From: Grant Harlow <GHarlow@martens.com.au>
Sent: Monday, 30 August 2021 9:00 PM
To: Christopher Fraser
Cc: Rob Brook [Newcastle Legal]; Paul Mitchell; Daniel Martens; carlod
Subject: RE: DA S29/3/97-Mod-1 - Eastern Creek Karts - Request for Information

Hi Chris, Please refer to tabulated response below to DPIE RFI date 19.08.2021 and referenced items in the following drobox link:

DWG No: LPS4.55 - 22/31	SHEET: 01	ISSUE: A	DRAWN: EW	CHECKED: RF

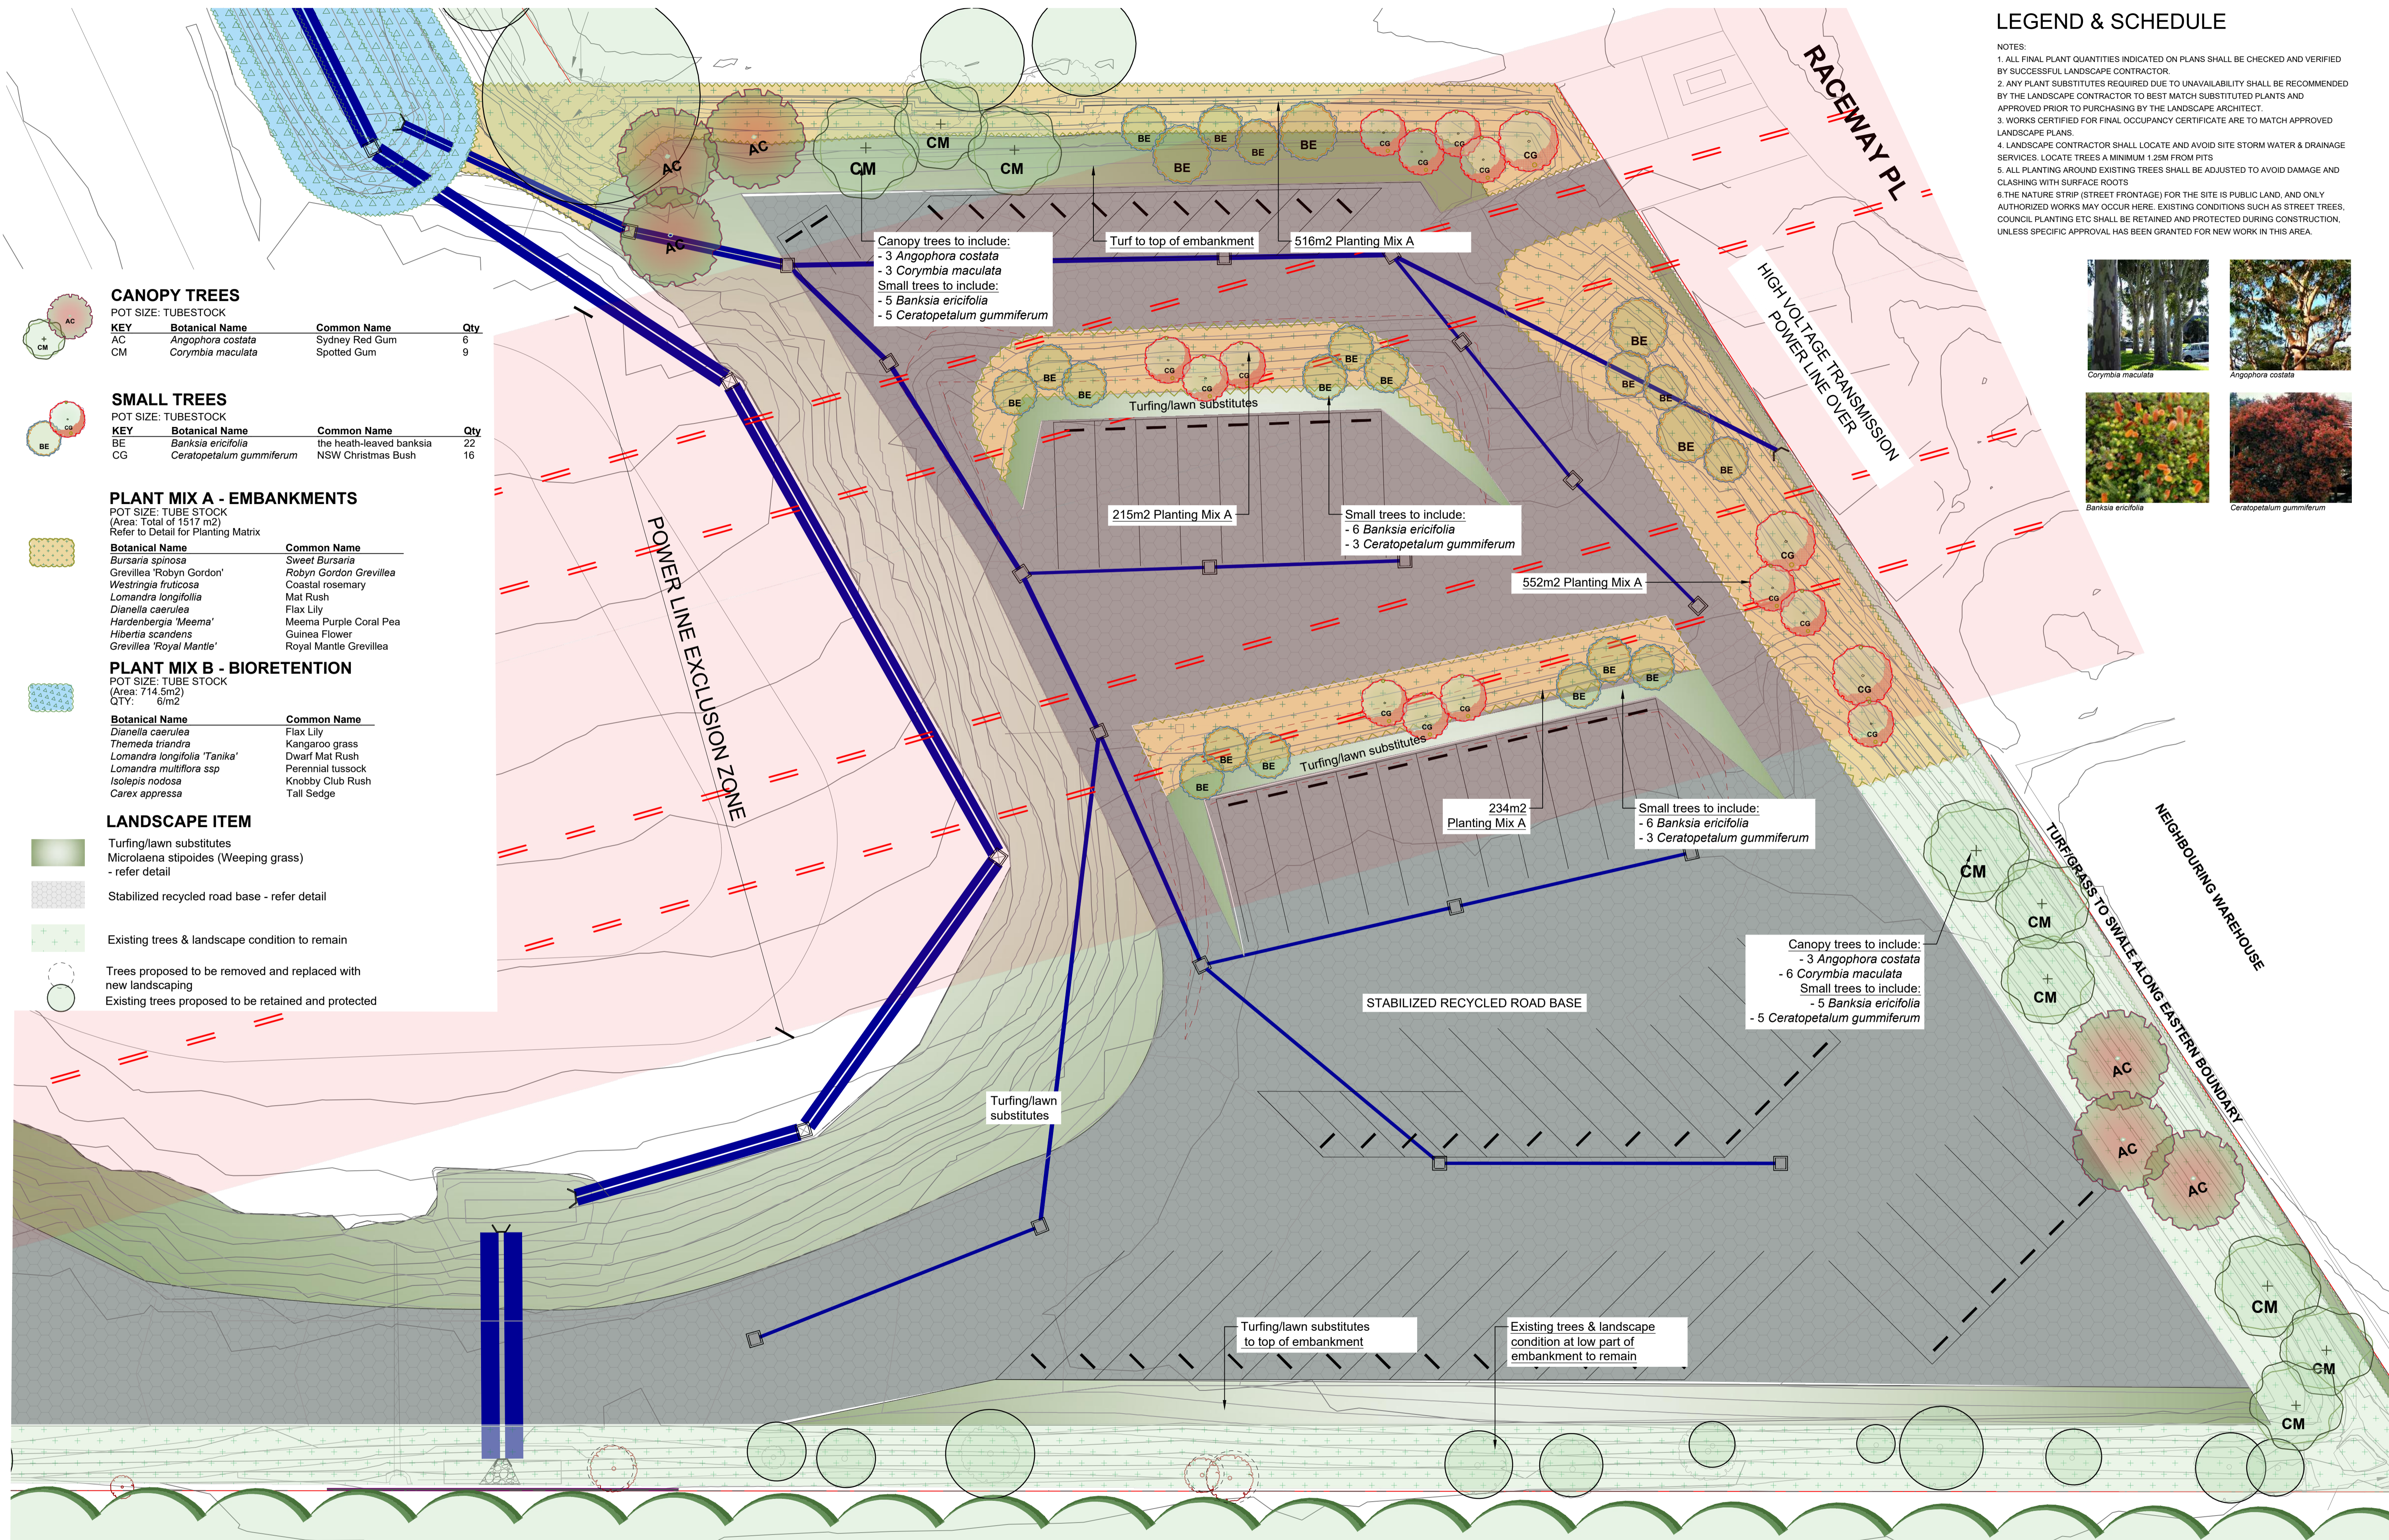
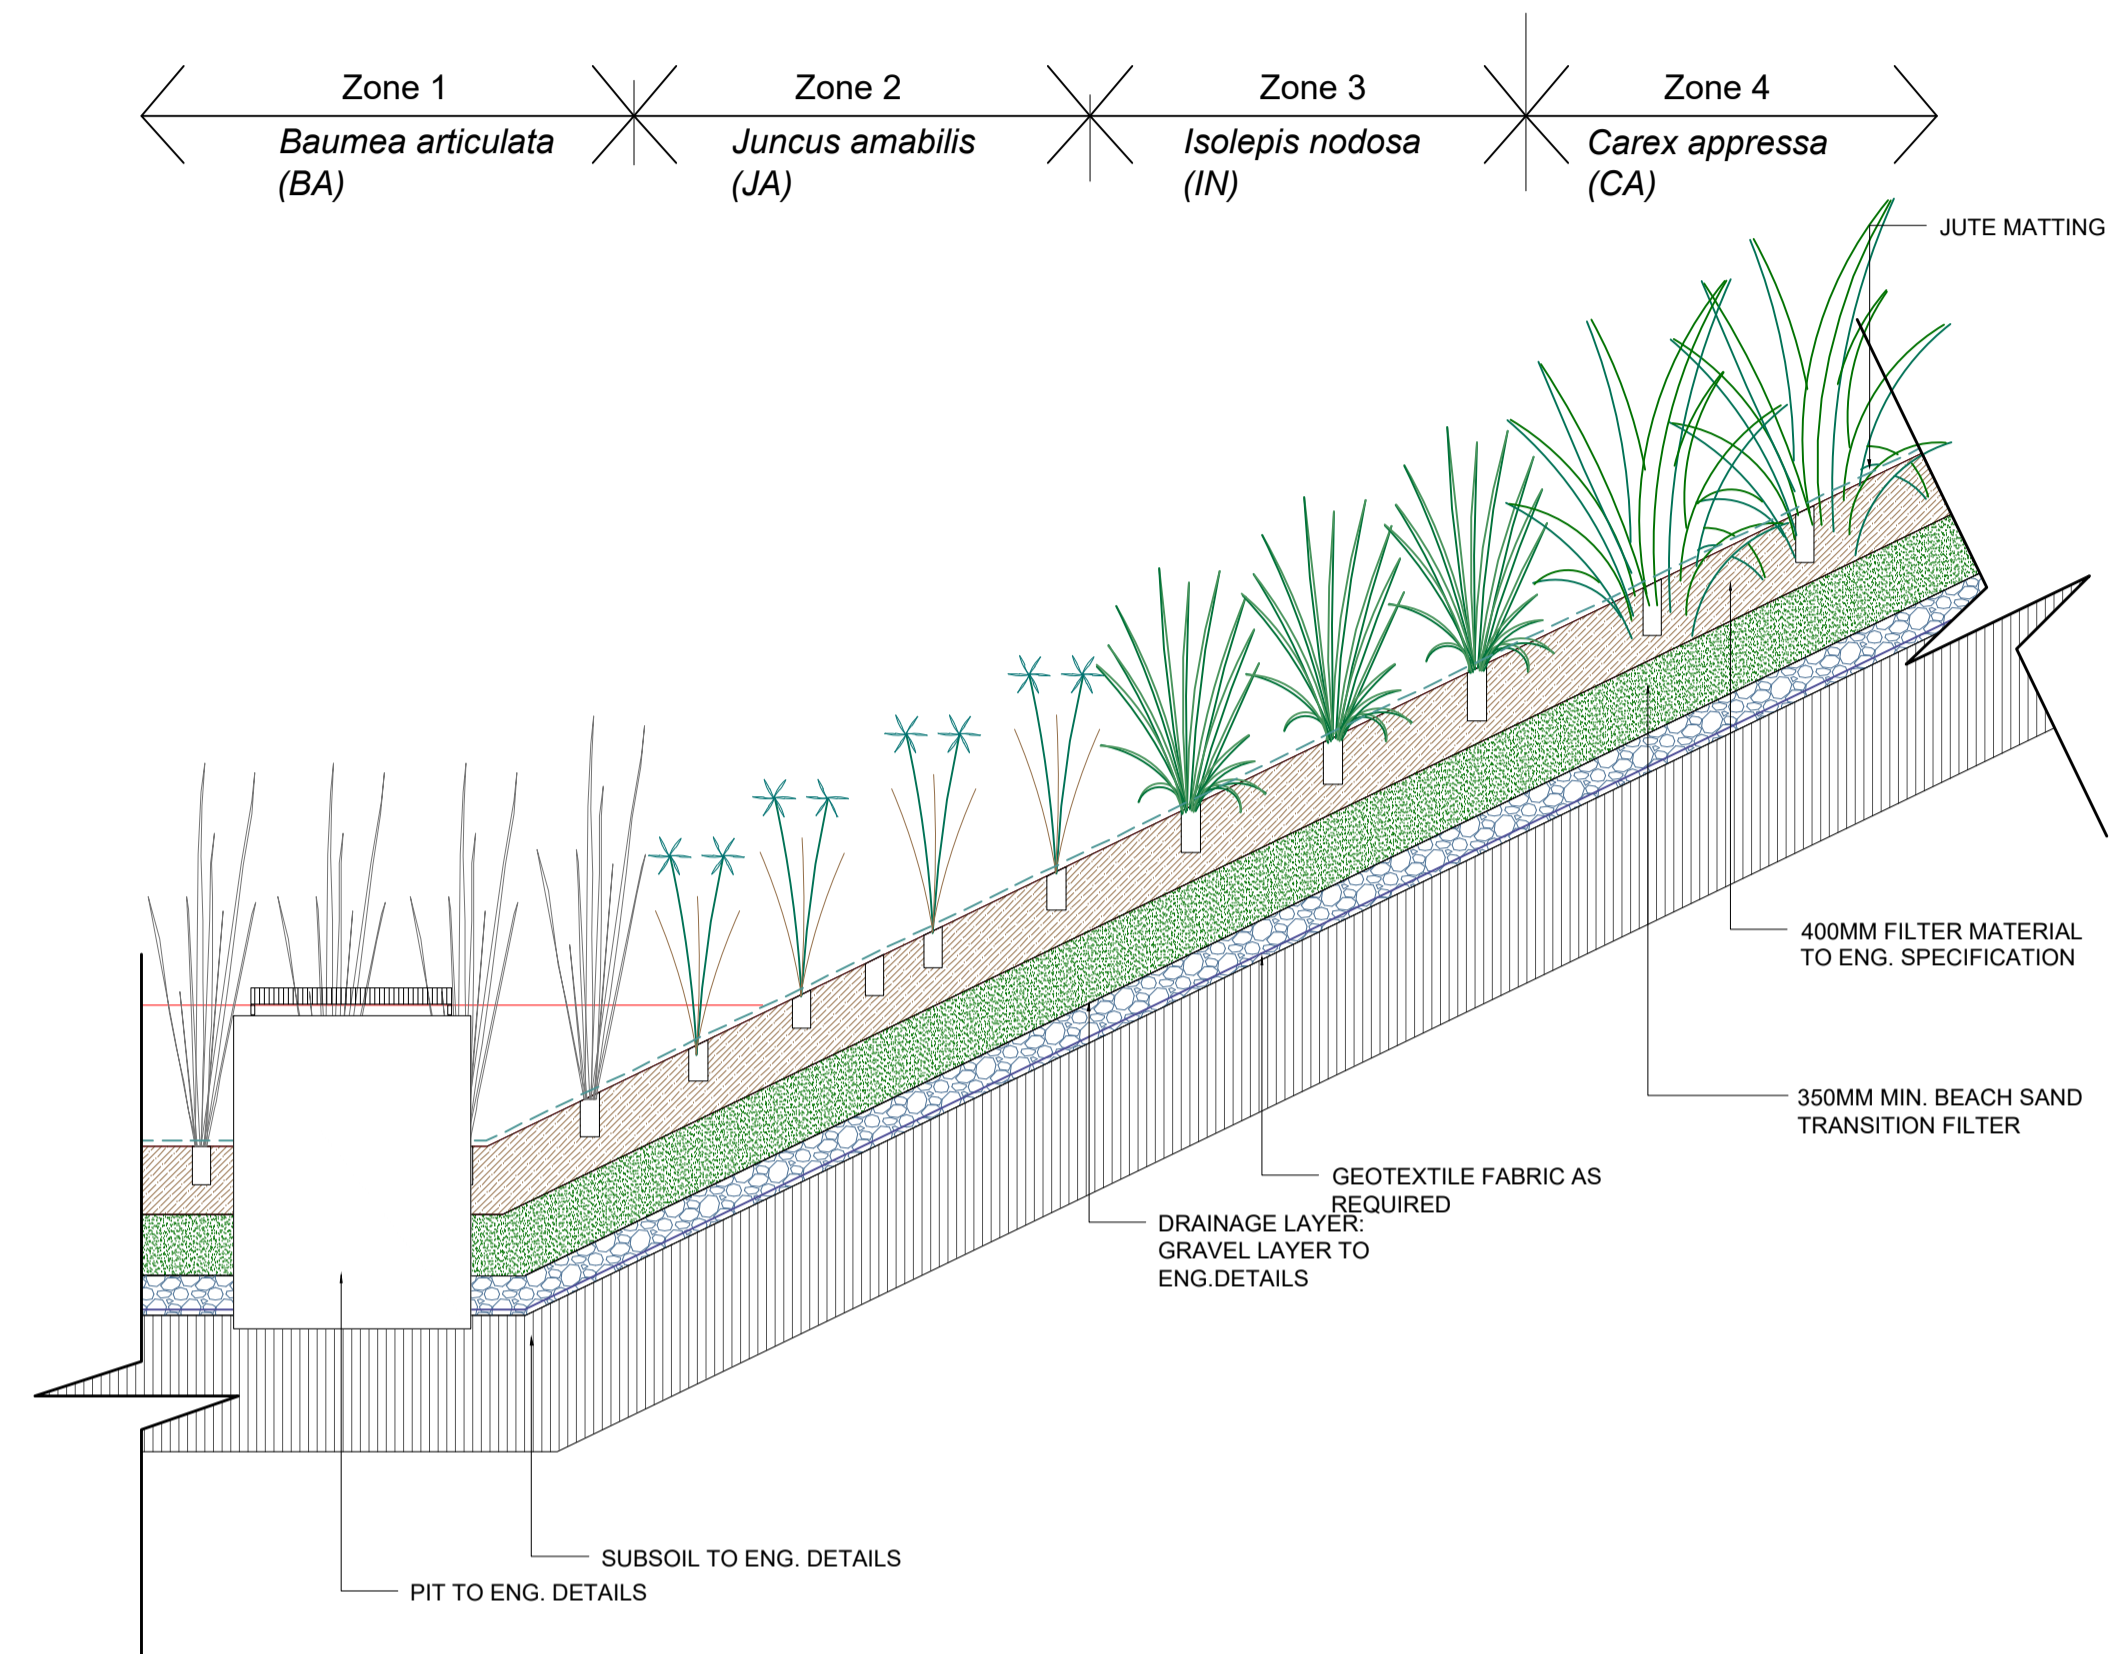
3. Proposed Landscaping on steep batters Landscaping Plan LPS4.55 - 22/31 by Conzept Landscape Architects is noted. Concern is raised for the planting of tall canopy species Angophora costata and Corymbia maculata in areas : • near proposed pipe drainage, or • on steep batters and retaining wall systems that may not have anticipated all design load surcharges. It is requested the Engineer and Landscape Architect confirm suitable locations for the canopy species where mature tree growth would not impact the service life of drainage pipes, and the Engineer provide assurance for the structural capacity and safety of the proposed batter and retaining wall systems given the canopy trees' anticipated surcharge loadings. Should any planting be reconsidered due to drainage or structural capacity concerns, please provide a revised planting design prepared by the Landscape Architect and supported by the Engineer in writing, to address matters of visual impact raised by the Department in the RFI letter of 13 May 2021 Appendix 1 Section 6.	The landscape architect has amended to the Landscaping Plan to remove the tall canopy species trees and replace with much smaller, lighter alternatives.
